## Comments on the Applicant's D2 Submissions

This document sets out the comments by Cambridgeshire County Council (**CCC**) on the Applicant's Deadline 1 (**D1**) submission, Applicant's Responses to the Examining Authority's Written Questions [REP1-079]. The table below provides the relevant paragraph or reference numbers.

### 8.3 Applicant's Responses to the Examining Authority's Written Questions [REP1-079]

Drawing Number
102375-MMD-01-XX-DR-C-DRAFT

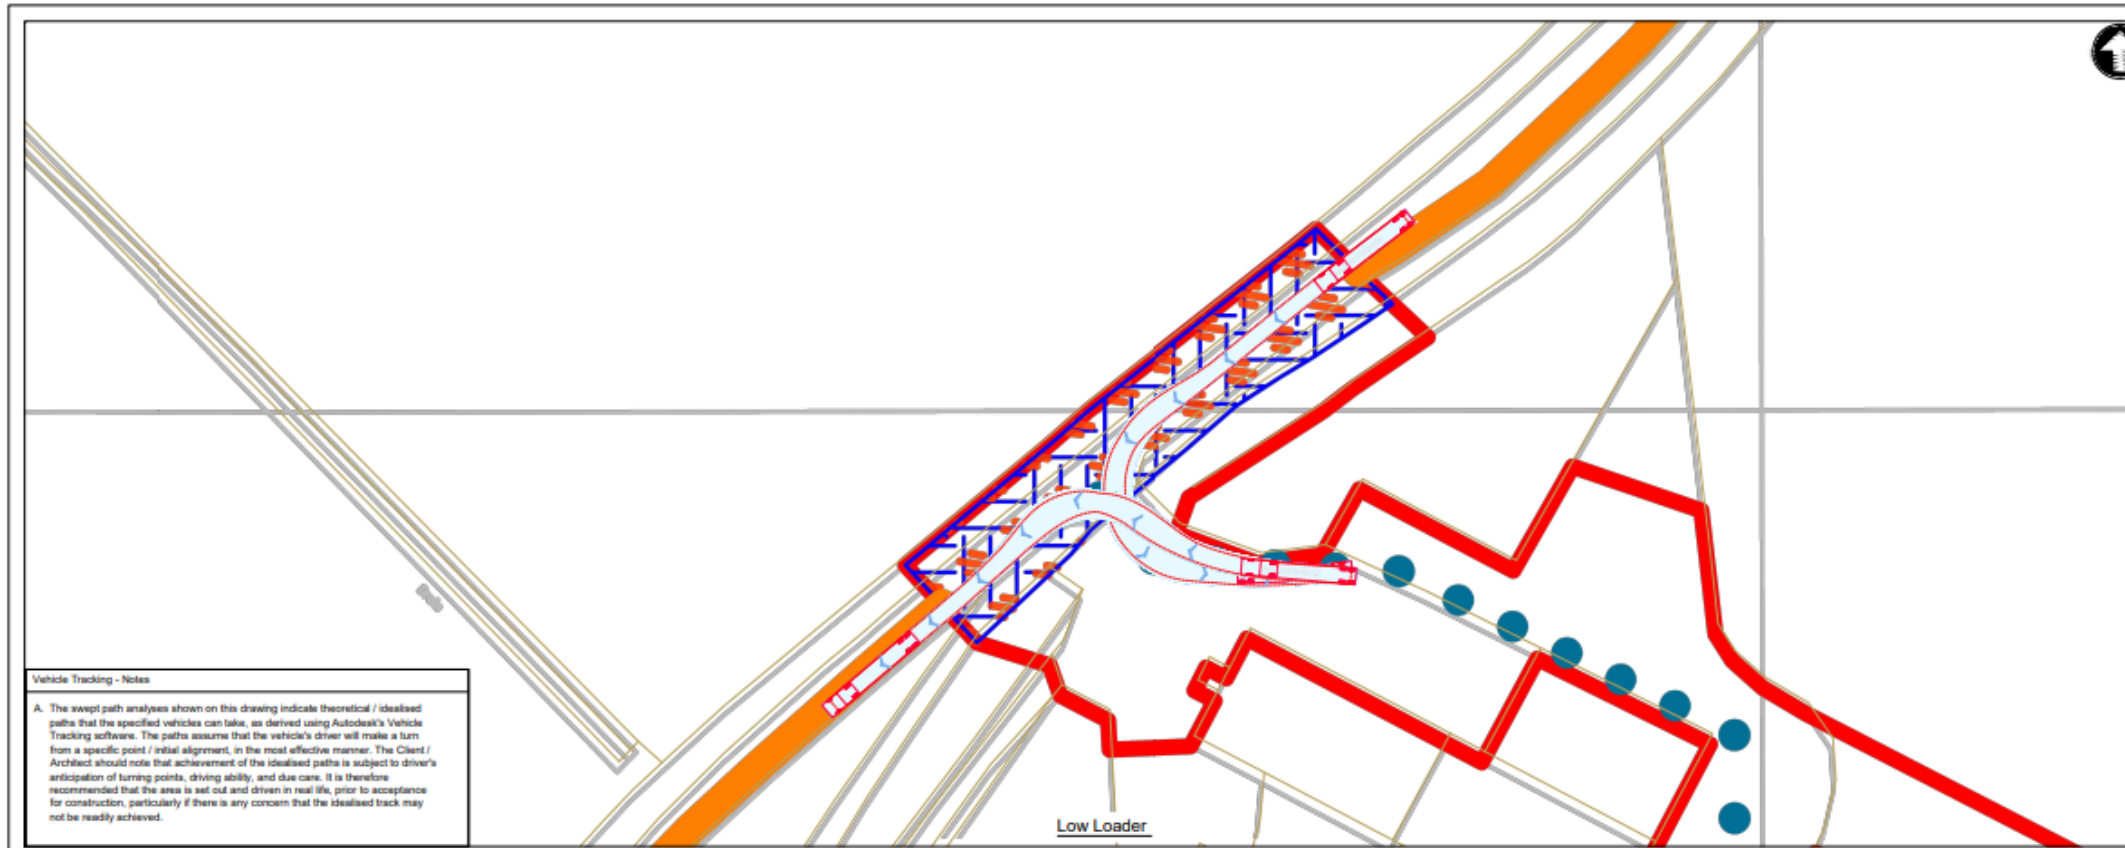
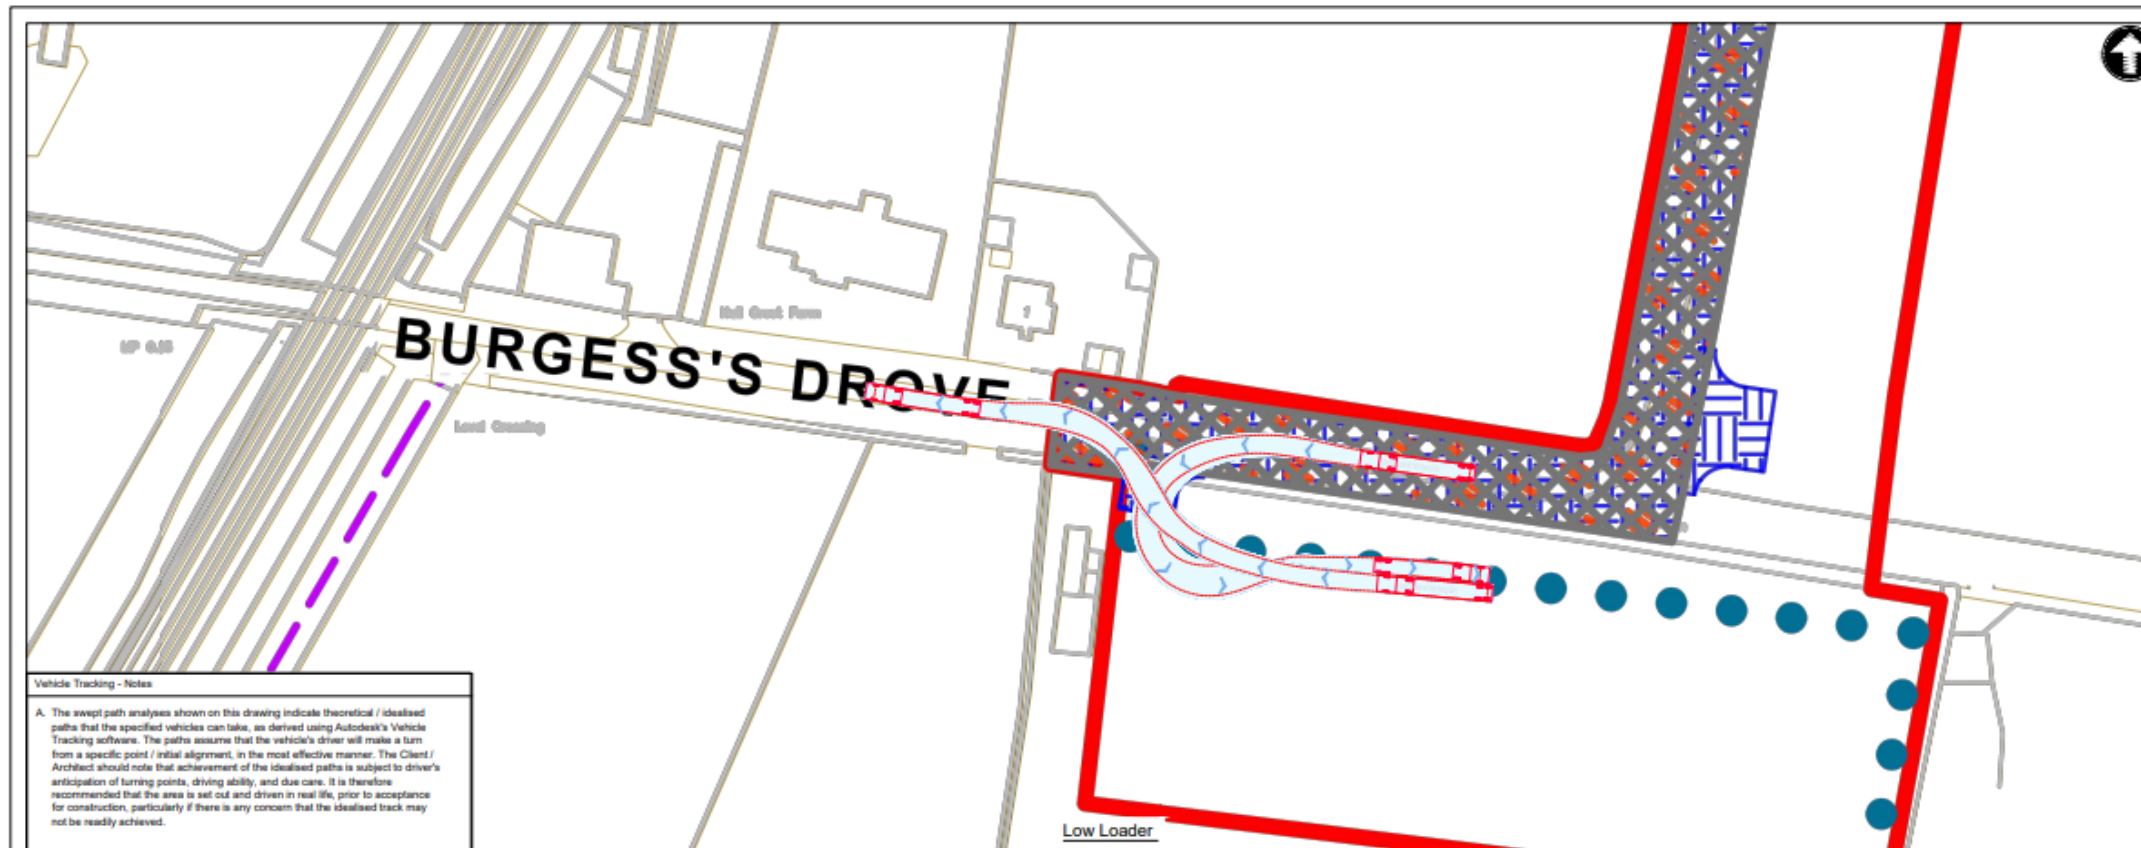
<p>of HGV traffic through the settlements of Horningsea and Fen Ditton. This requirement is recognised in the Construction Traffic Management Plan (CTMP) (App Doc Ref 5.4.19.7) [AS-109] and The Code of Construction Practice (CoCP) Part A (App Doc Ref 5.4.2.1) [APP-068]. The CTMP [AS-109], Section 4 'Access and Route Strategy' provides details on vehicle routing and Section 6.3 'Adherence to Designated Routes' outlines the measures in place for the adherence to designated routes. Furthermore, the CTMP (App Doc Ref 5.4.19.7) [AS-109] Paragraph 6.9.10 states the commitment to avoid routing HGV movements through Waterbeach during school drop-off and pick-up hours during term time.</p> <p>f) The Applicant took part of a Traffic Working Group (TWG) meeting on the 27 May 2021, held with CCoC and National Highways to discuss construction route options. CCoC noted at the meeting that the monitoring and enforcement of the construction routes would be a sensitive issue especially with regards to construction traffic at Waterbeach. The ES Chapter 19 (App Doc Ref 5.2.19) [AS-038], Table 1-4 outlines the matters discussed at TWGs between the Applicant and 222 ExQ1 Question to Question Response consultees. The Applicant has produced swept path drawings for the Hartridge's Lane / Clayhithe Road junction, available at Appendix G of the Transport Assessment Part 2 (App Doc Ref</p>

<p>5.4.19.3) [AS-108b] (drawing 102375-MMD-01-XX-DR-C-DRAFT) and shows a red boundary which represents the land that would be potentially required for the access of construction traffic. Additionally, the dDCO (App Doc Ref 2.1) [AS-139] Part 3 Requirement 10 grants the Applicant the powers to carry out street works on streets listed in Schedule 3 'Streets subjects to street works', which includes Hartridge's Lane.</p> <p>g) Applicant took part of a Traffic Working Group (TWG) meeting on the 27 May 2021, held with CCoC and National Highways to discuss construction route options. CCoC noted at the meeting that the monitoring and enforcement of the construction routes would be a sensitive issue especially with regards to construction traffic at Waterbeach. However, no issue was raised specific to Bannold Road and Long Drove. The Applicant has responded to local residents to confirm Long Drove would remain open to residents to pass throughout the work, as would Bannold Drove. The Applicant has produced swept path drawings for Bannold Road (drawing title 'temporary access junction COA14') and Long Drove (drawing title 'temporary access junction CA29'), available at Appendix G of the Transport Assessment Part 2 (App Doc Ref 5.4.19.3) [AS108b] which show that there would be no accessing the works site on Bannold Road and Long Drove but that there are restrictive road widths. Additionally, the dDCO (App Doc Ref 2.1) [AS-139] Part 3</p>
